From: Simon Davis
Sent: 02 November 2021 16:51
To: Planning Scanning
Subject: FW: BR/222/21/PL Vincent House

From: Simon Davis
Sent: 02 November 2021 16:50
To: 'Nick Hopper' [REDACTED]
Subject: Re: BR/222/21/PL Vincent House

Further to my last message, I have been writing the report up today and I noticed that the proposed flats do not accord with the space standards requirements. Extract from my draft report for your information:

South Elevation (Proposed) 1:100

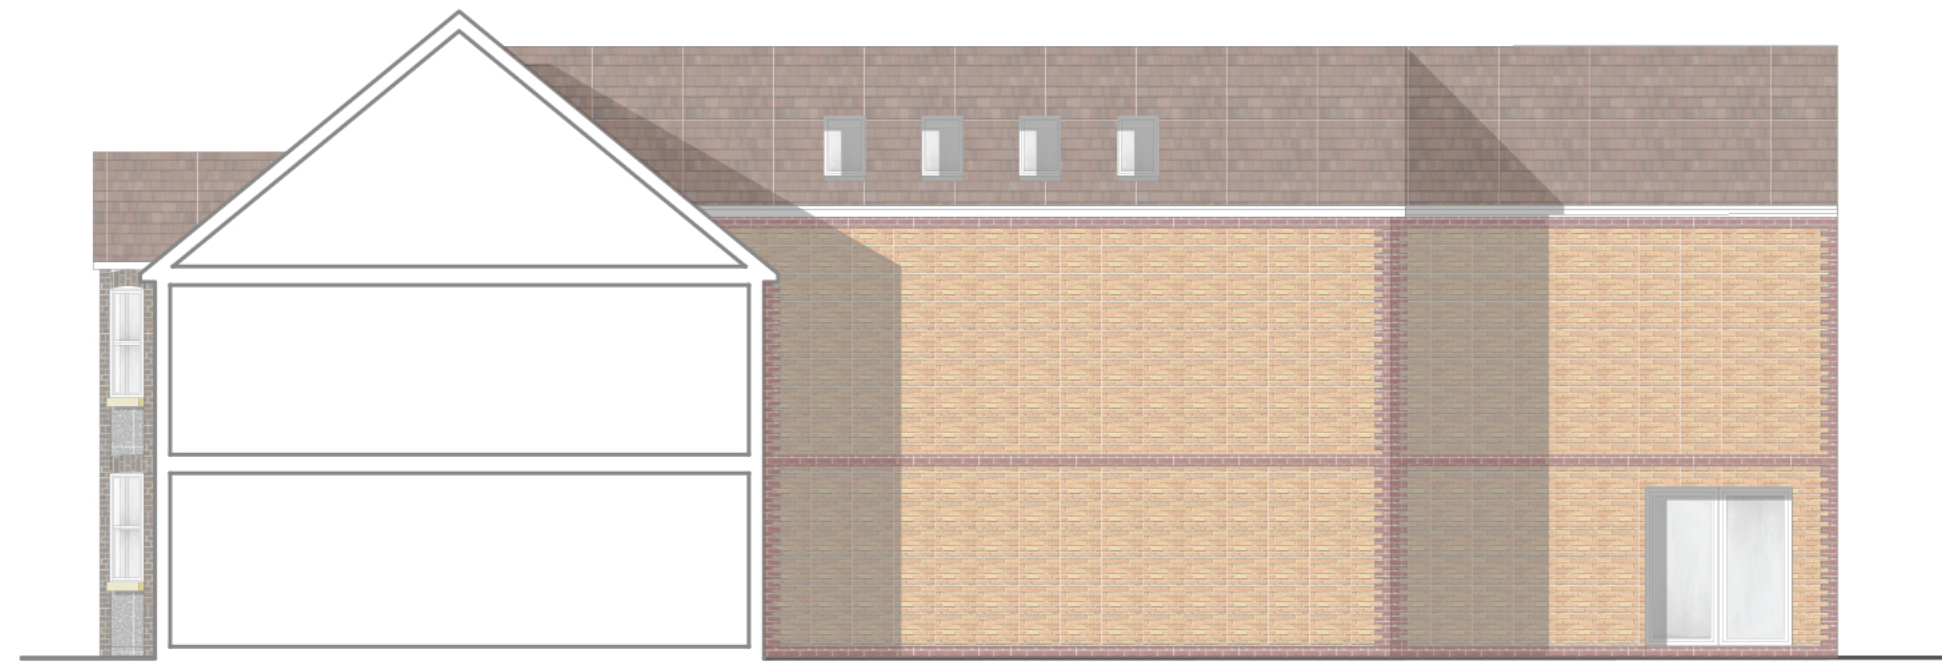
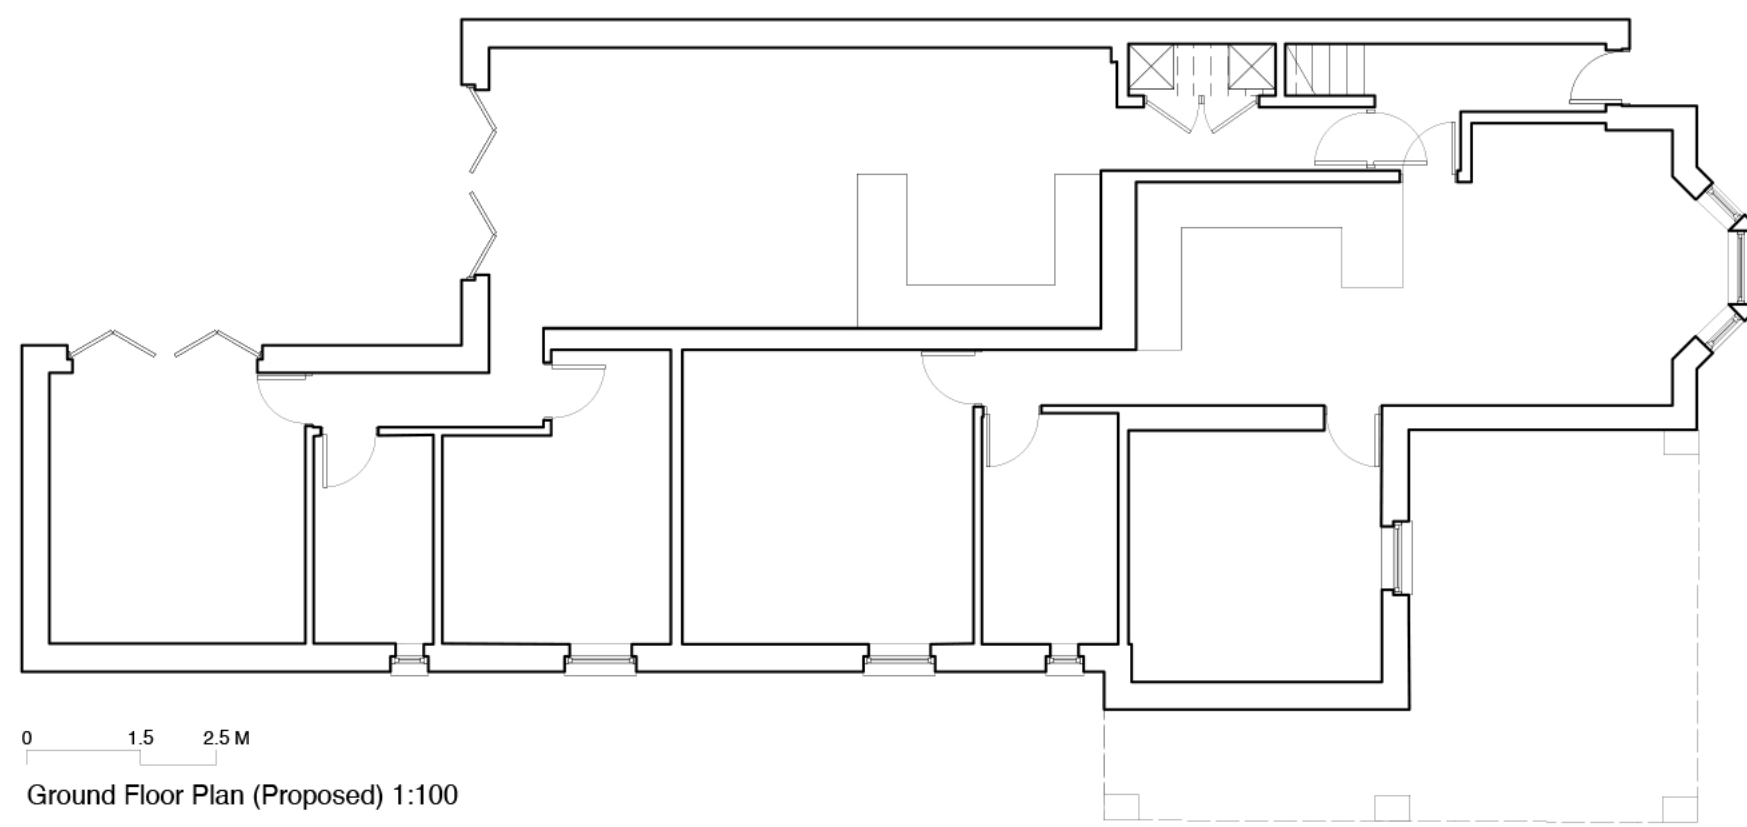
I have also spotted some inconsistencies with the drawings in that there are more roof lights shown on the second floor plan than are shown in the elevations. These would need to be resolved and any drawing changes may require further publicity as they affect neighbours.

Second Floor Plan (Proposed) 1:100

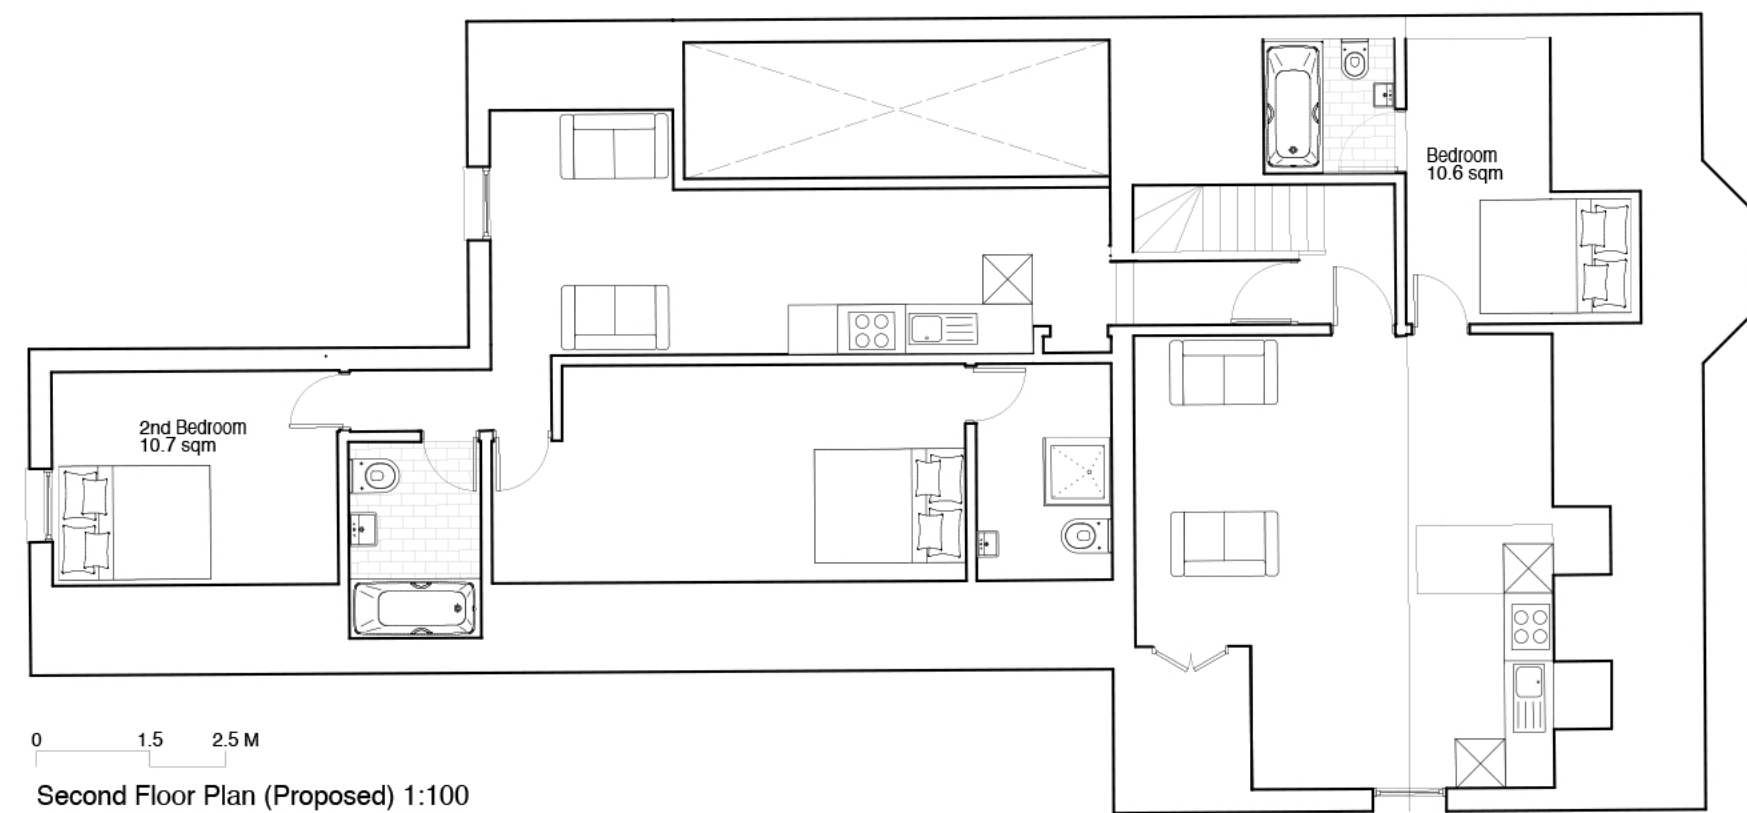
The required internal space standard for the 1 bed flat is 50m² and for the 2 bed flat is 70m². Neither of the flats comply with the requirements with 41m² for the 1 bed flat and 63.5m² for the 2 bed flat. The application plans suggest that the 2 bed flat should be considered as a 2 bed, 3 person unit thus only requiring 61m² however, the space standards state that a double or twin bedroom has a floor area of at least 11.5m². Given that both bedrooms are at least 11.5m², it is appropriate to assess the 2 bed flat as a 4 person dwelling. On this basis, neither flat provides an appropriate size of living accommodation. Whilst policy D DM2 does allow for flexibility with building conversions, the shortfall in both cases is significant and this would result in harm to the amenity of future residents in conflict with policy D DM2 and the good design principles in the NPPF.
